East Preston Parish Council comments

From: East Preston Parish Council (SC) [REDACTED]
Sent: 04 May 2022 13:00
To: Planning.Responses <Planning.Responses@arun.gov.uk>
Subject: East Preston Parish Council comments on EP/39/22/HH

Proposed Roof Plan
1469/NA18A
Scale 1:100 at A3 .

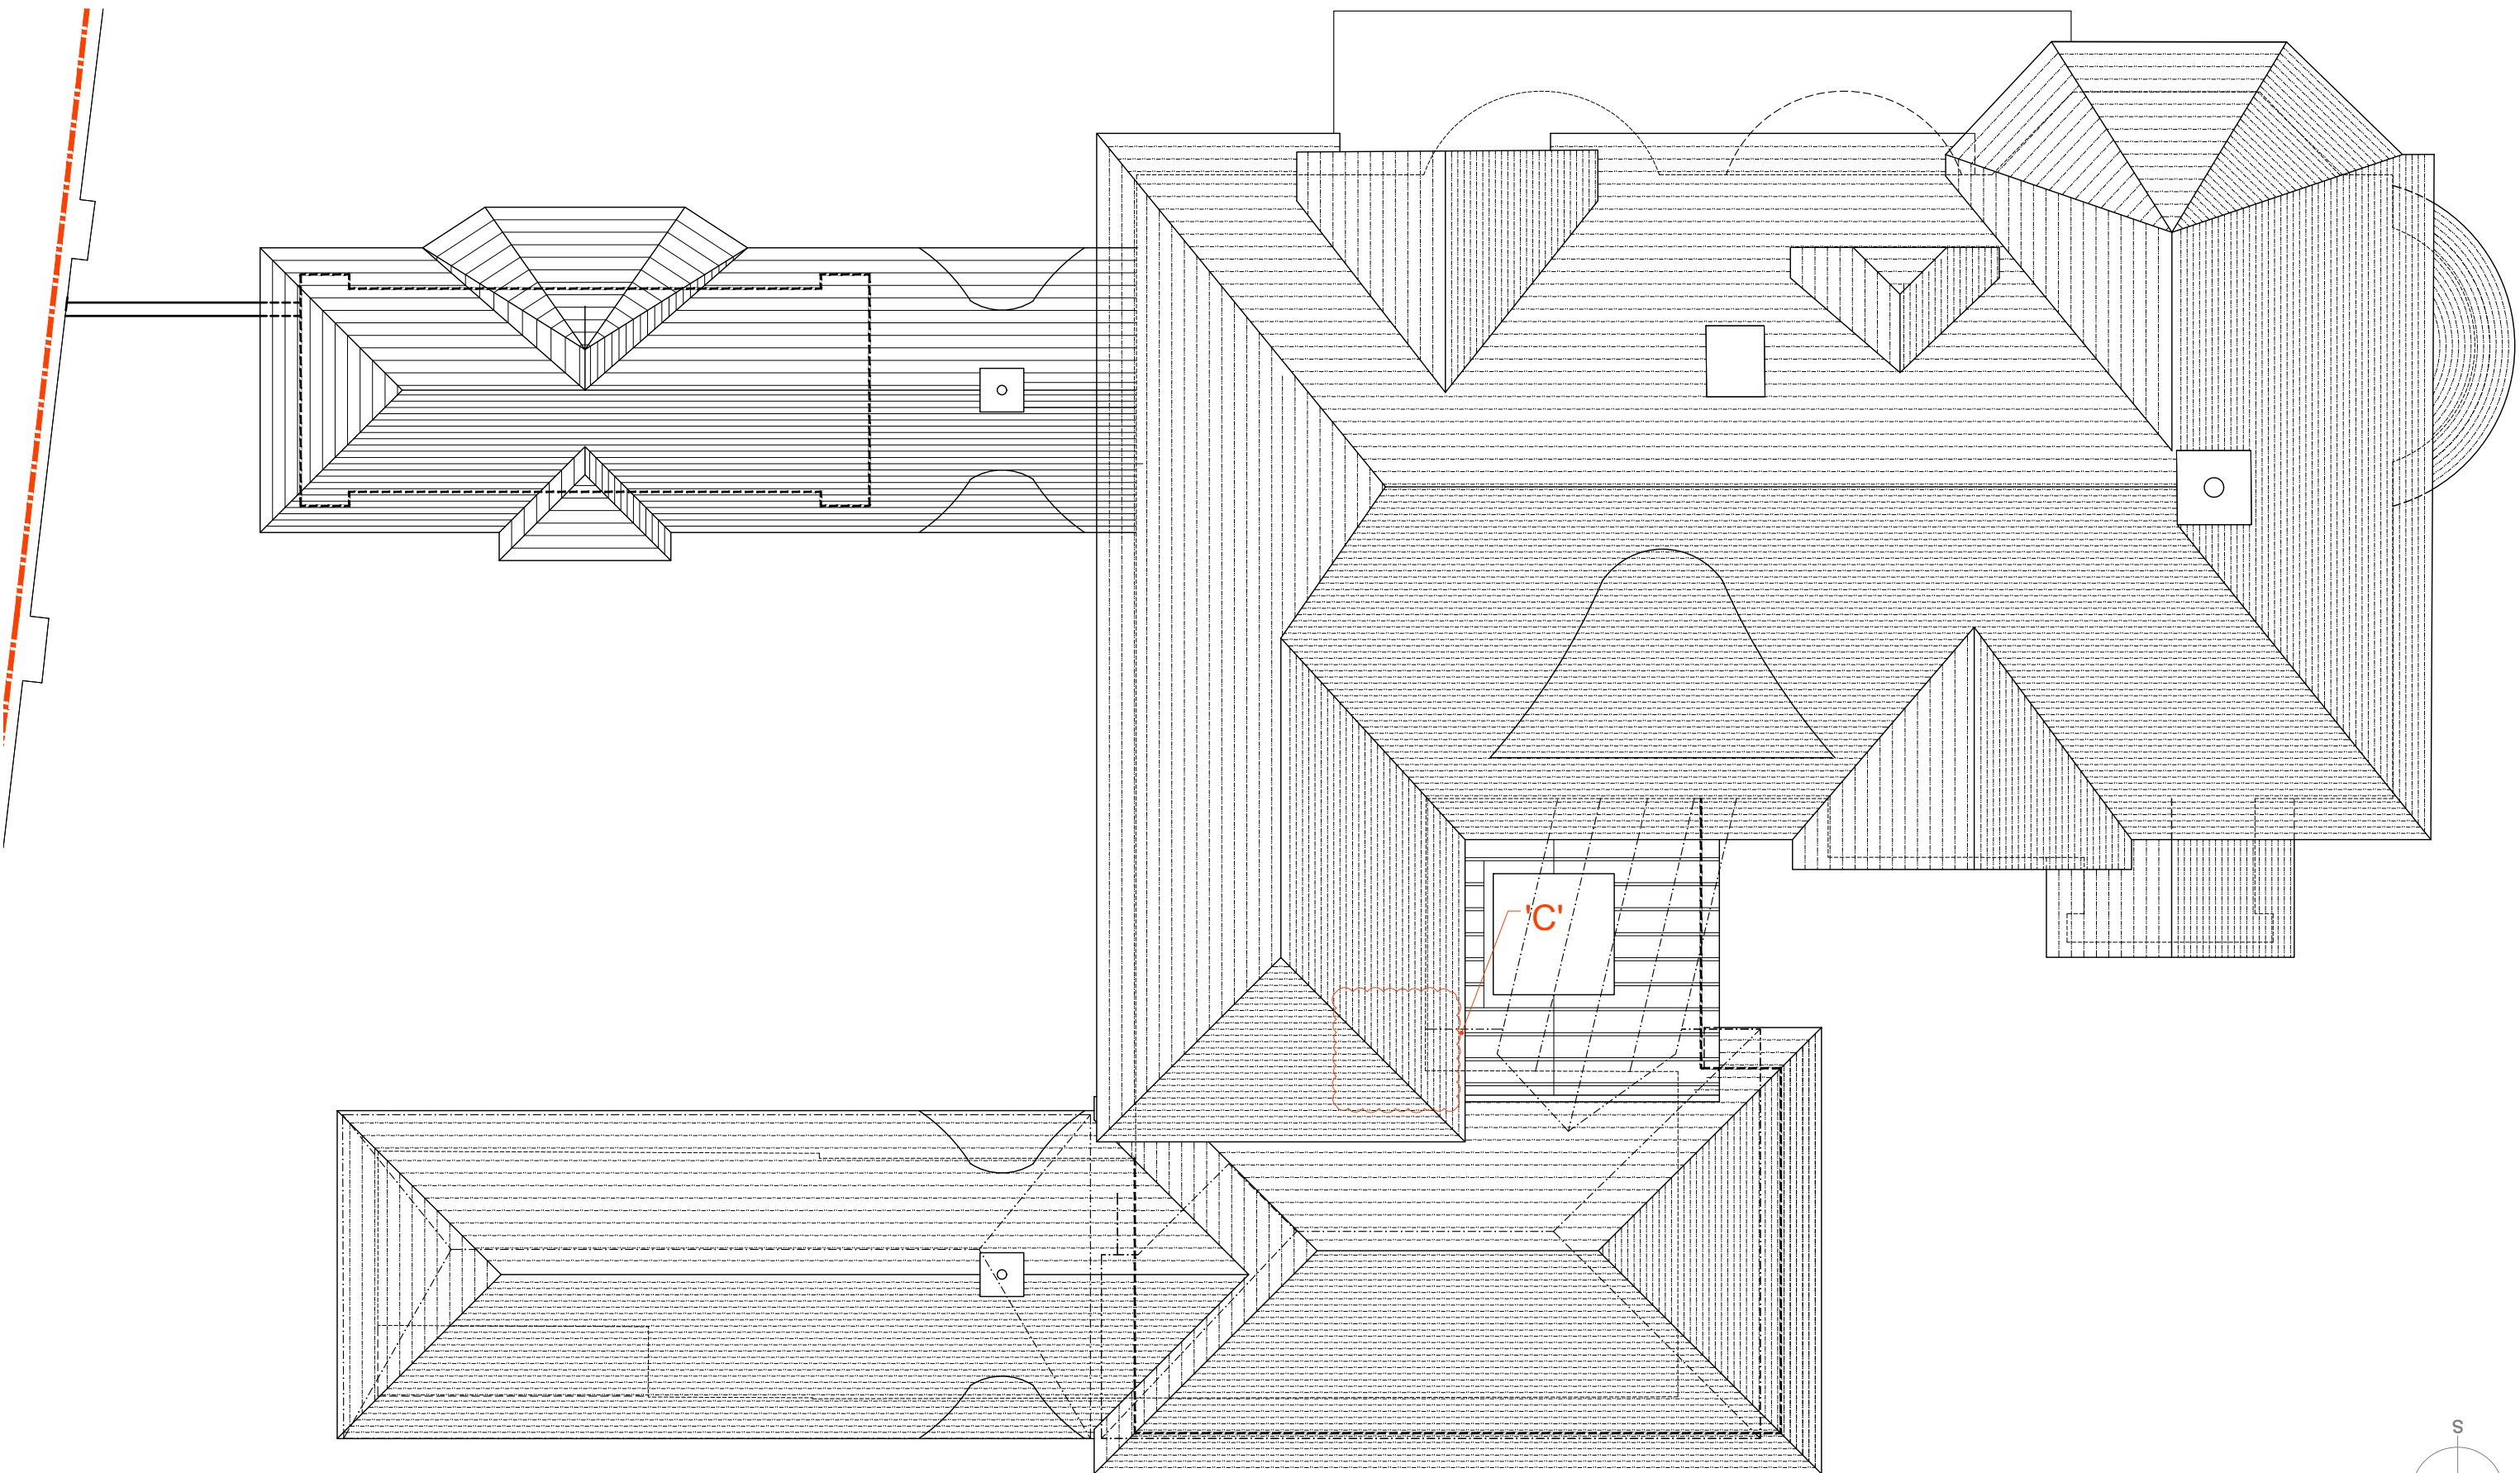
However, the committee was concerned about the removal of a chimney and the removal of the browed eaves above the windows. The applicants, having explained the reasoning behind the proposed changes, agreed they would revert to their agent and architects in case there are ways of mitigating this loss. The committee appreciate this offer.
